Online Comment

Application H09-0523-20
Location Land off Damgate Holbeach Spalding
Proposal Details of Conditions 3, 4, 5, 6, 7, 8, 9, 10, 11, 13, 14, 15, 16, 17, 18, 19, 20, 21, 22 and 23 H09-0332-16

I have reviewed the GeoDyne 'Dam Gate Holbeach Remediation Method Statement Project No: D38108 Date: 18th August 2020', Ashwood Homes Ltd Drawing 'Gas membrane details' ref 35-GMB-01 Rev B' dated August 2020 and clarification email from Andrew Riley dated 01-09-2020.

DRAWING: Gas Membrane Details

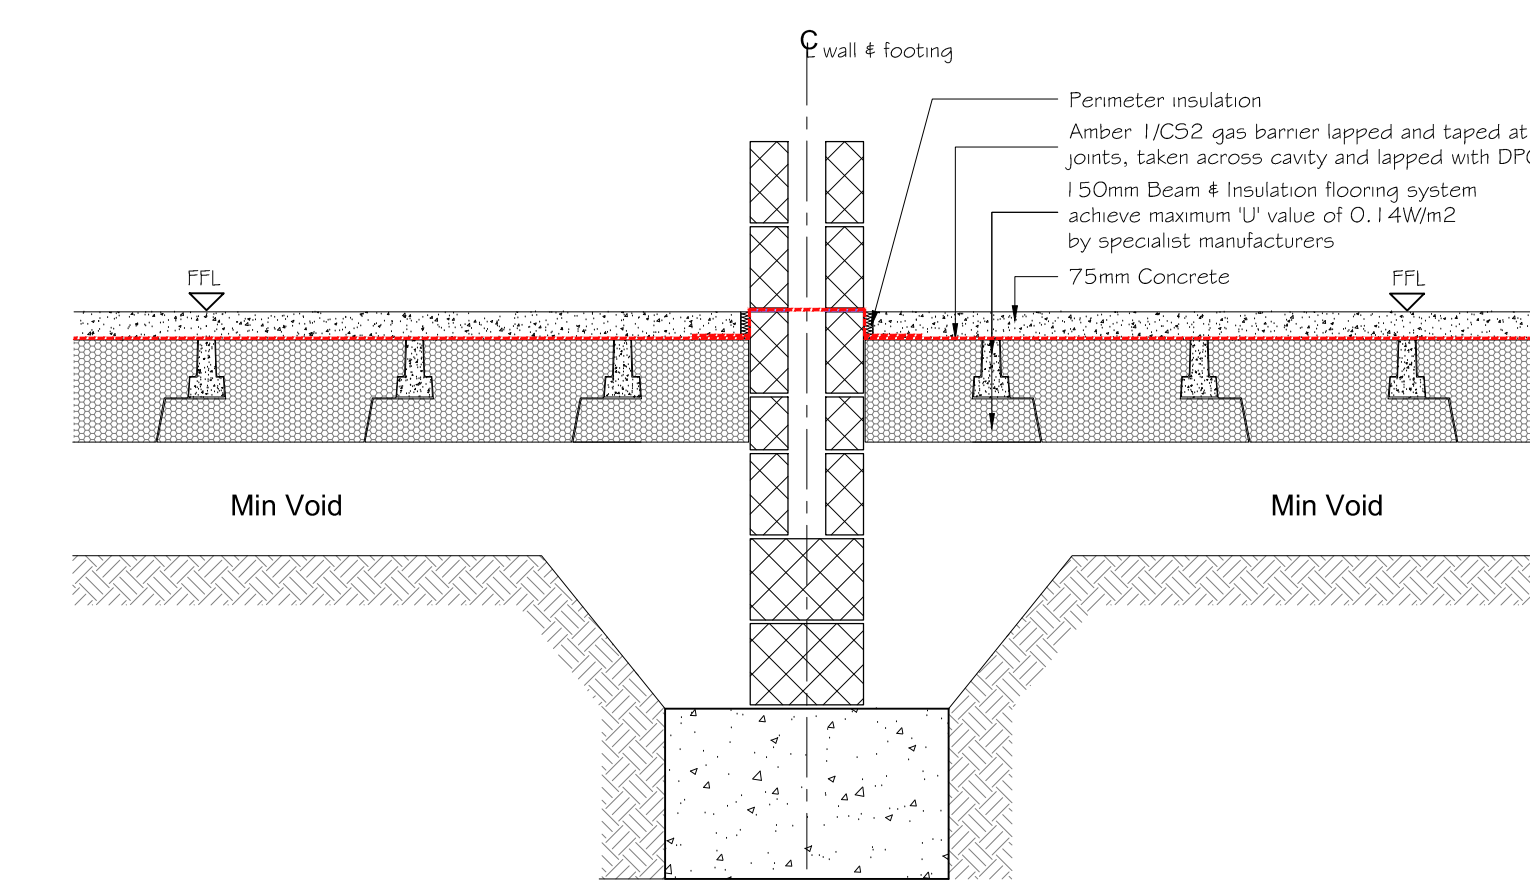
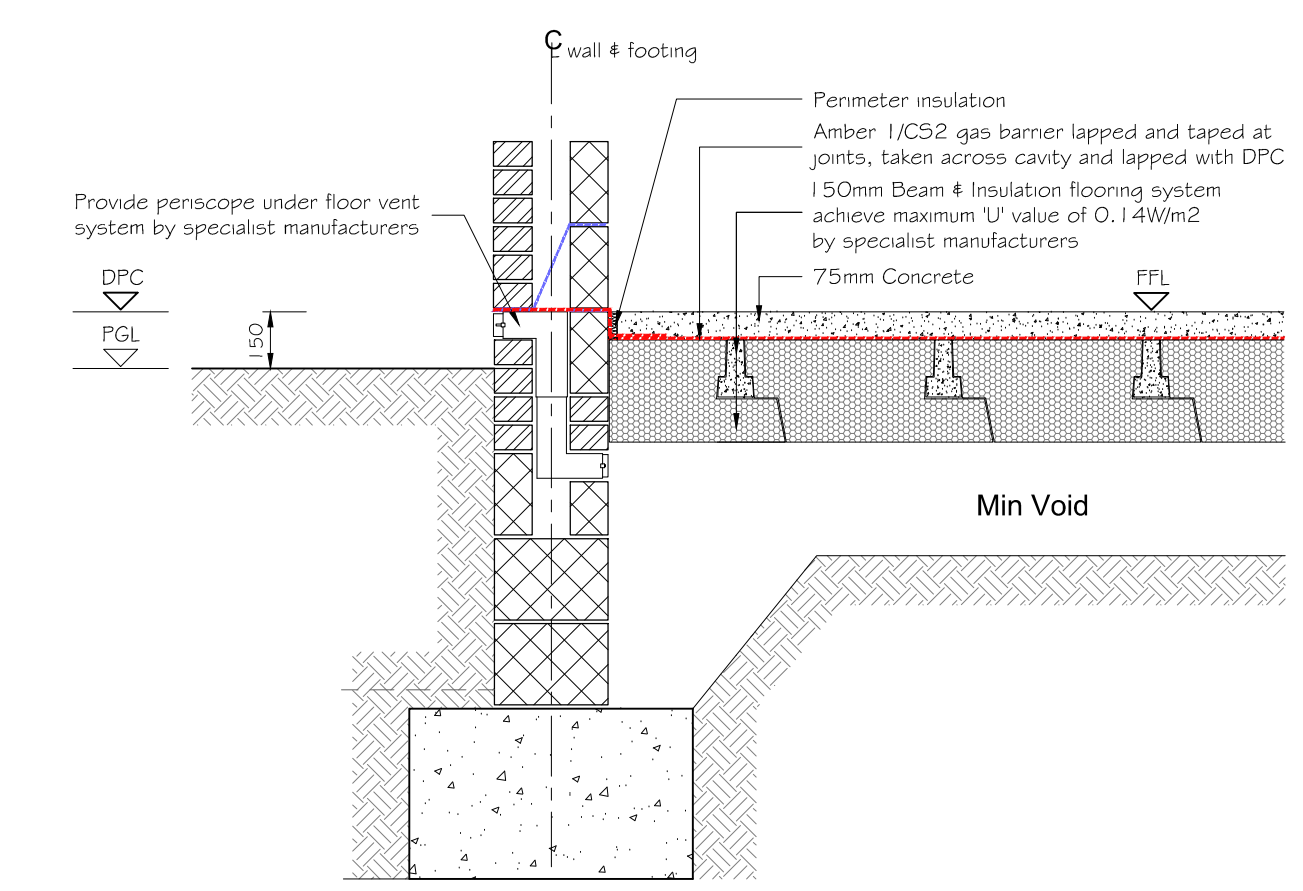
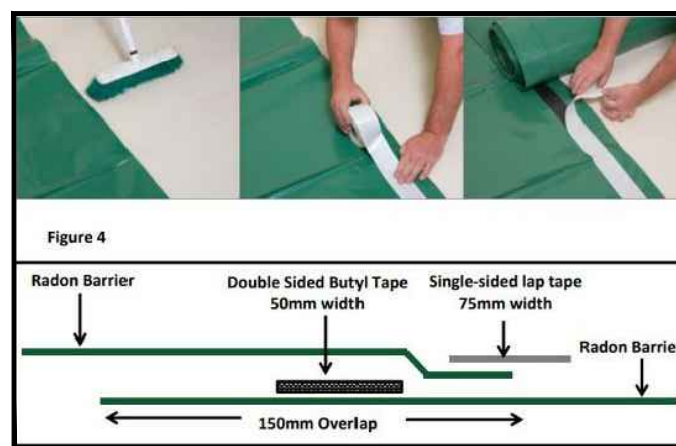
I am in general agreement with the report and the proposed drawing and recommend discharge of part iii of condition 3 of H09-0332-16 with part iv remaining outstanding. I look forward to receipt of the validation report in due course.
